RE: VA-19-00001 Berlin – Deem Incomplete and Request for Additional Information

Kittitas County Community Development Services (CDS) received your Zoning Variance Application on January 23, 2020 to reduce the front setback from Fern Drive down to five (5) feet for a new garage. The definition for a Yard Front in Kittitas County Code (KCC) 17.08.590 states: “Front yard” means any yard abutting a public or private street. The subject property is zoned Rural Recreation. Fern Drive, a private road, has a Front Yard setback of 25’ pursuant to KCC 17.30. This parcel is located at 30 Fern Drive, in a portion of Section 34, T21N, R14E, WM in Kittitas County, bearing Assessor’s map number 21-14-34053-0217. Your application has been determined incomplete and additional information is required.

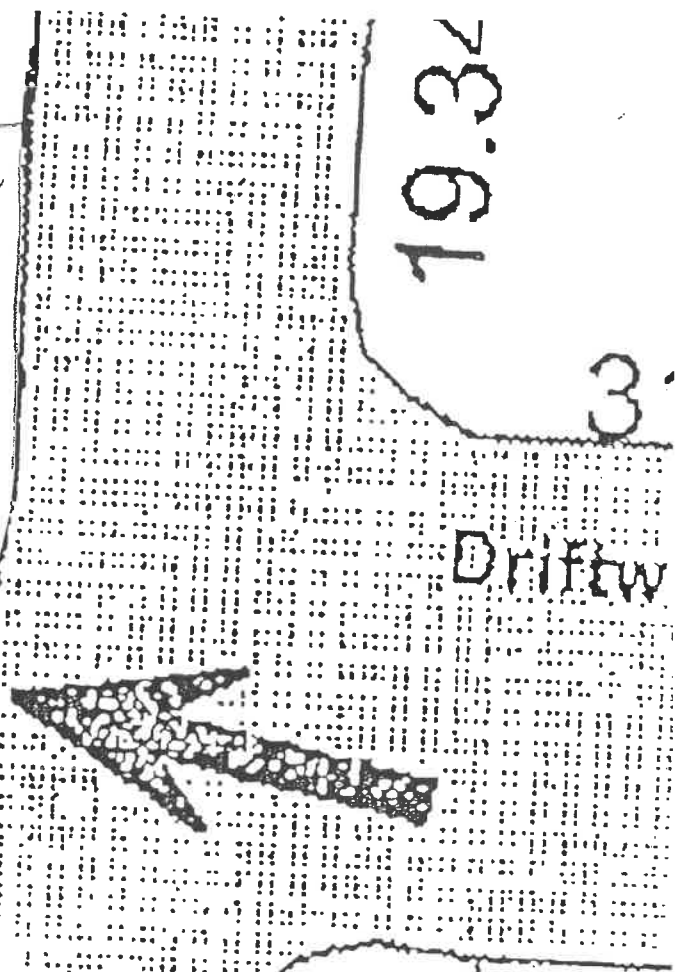
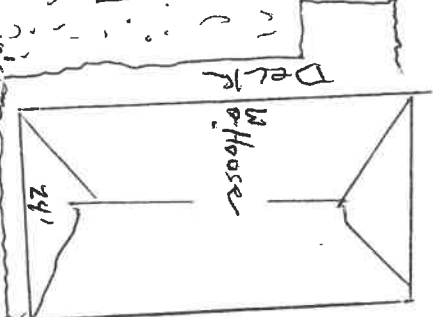
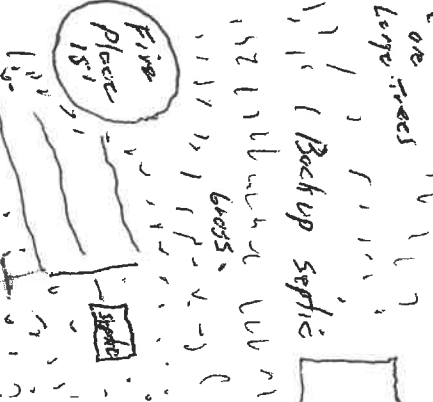
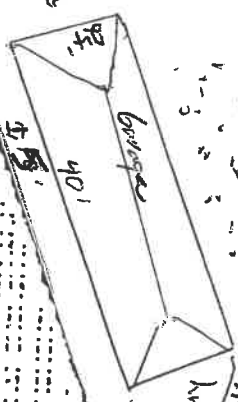
After review of the submitted site plan and application, we have determined that in order to be considered a

complete application submittal consistent with the above, the following items are needed:

1. In relation to KCC 15A.03.030, please provide an updated site map that shows all setbacks from existing and proposed structures along with all other site map requirements.
